**Re: Valerie Keating development at The Dunes, Seapoint, Termonfeckin,  
Co. Louth  
Section 5 2023/02**

**An Bord Pleanála Ref: ABP-316152-23**

**APPEAL STATEMENT**

**Description:** Whether the home office built within the property boundary is or is not placed forward of the front boundary wall of the house and whether it is or is not exempted development.

Figure 3 Site Layout

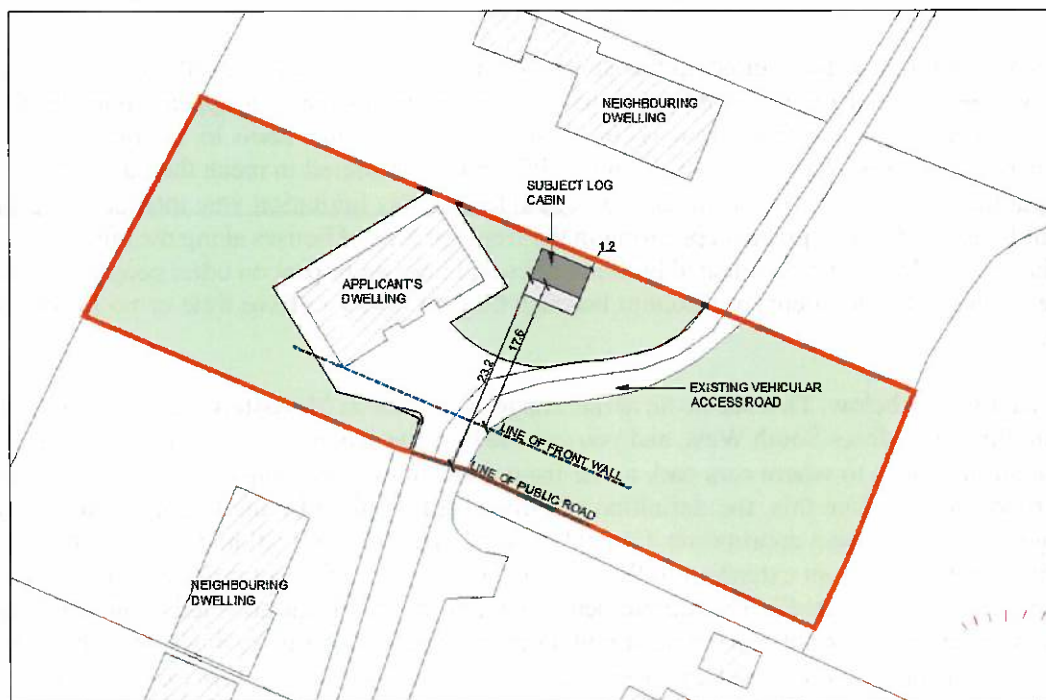
The first party appeal statement considers that the front wall of the house is as per the blue dashed line illustrated in Figure 3 below.

As outlined within the Planner's Report dated 28<sup>th</sup> February 2023, it is considered that the structure for which the question has arisen for determination in this instance, is placed forward of the existing front wall of the house and therefore does not comply with limitation no.1 of Class 3. No new matters for consideration have been raised within the appeal statement, and therefore, the Planning Authority does not have any further comment to make other than the assessment contained within the Planner's Report.
